Historic England

Our ref: P01508975

4 July 2022

**LAND OFF HERMITAGE PARK, LEPTON, HUDDERSFIELD, HD8 0JU
Application No. 2022/91735**

Appendix G HS2 & HS3 Joint Masterplan and Phasing Plan

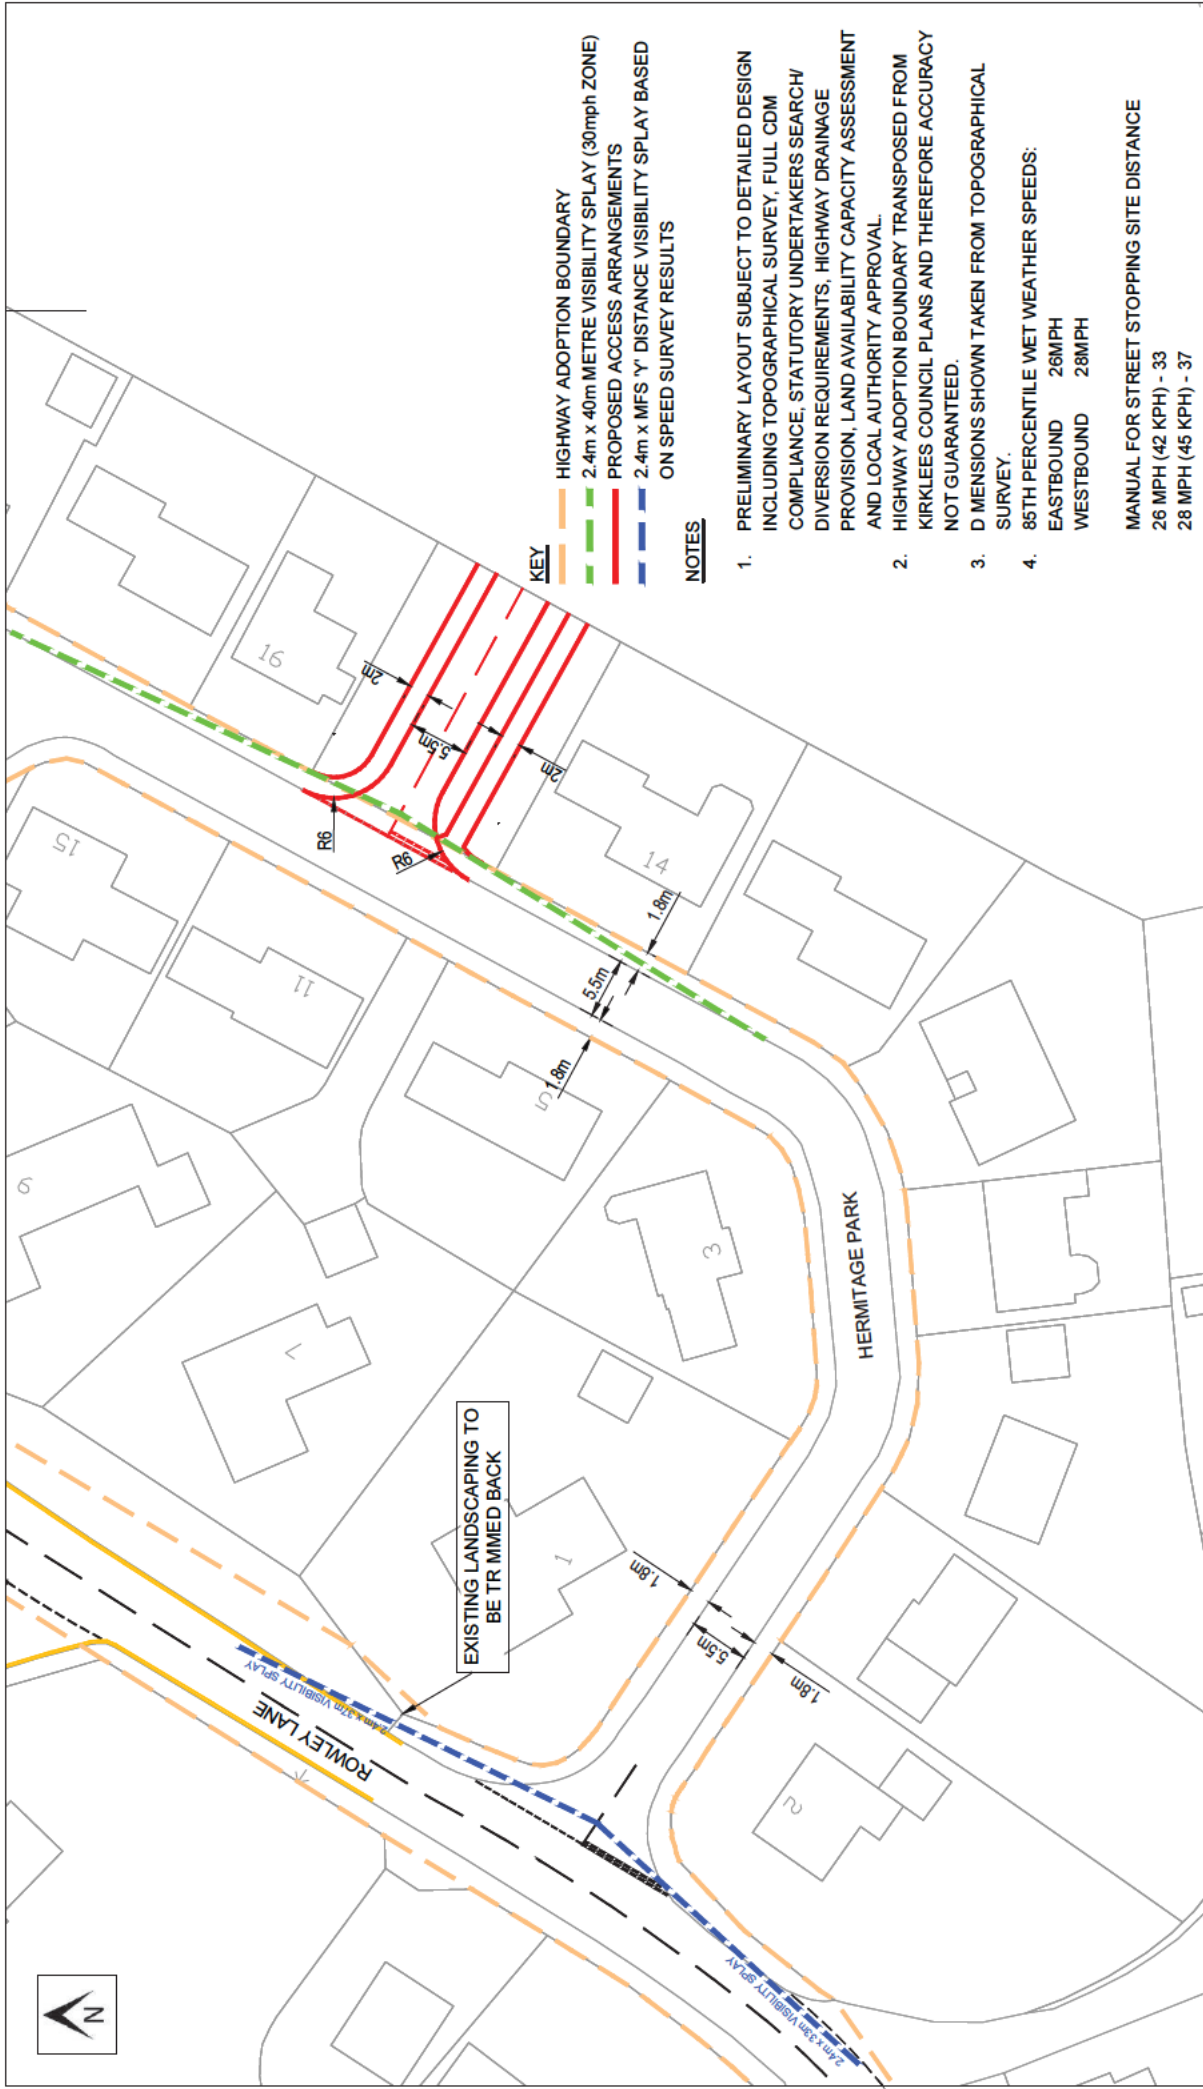
However, we wish to note that there are aspects of the wider joint masterplan that remain unresolved. In particular, the connection with the turnpike road is an important consideration, given its potential impacts on the setting of the Grade I listed Woodsome Hall, the Grade II listed no. 1 Woodsome road and on the rural character of this part of the site.

We have no objections to the layout proposed for this site, subject to detailed design codes and landscaping being discussed to the satisfaction of your expert conservation advisers. However, we note that the connection with Penistone Rd, important for the functioning of the site as a whole, has not been yet established. We therefore ask your authority is ensured this junction can be implemented in manner sympathetic to its context, if you are minded to grant consent for this part of the site.
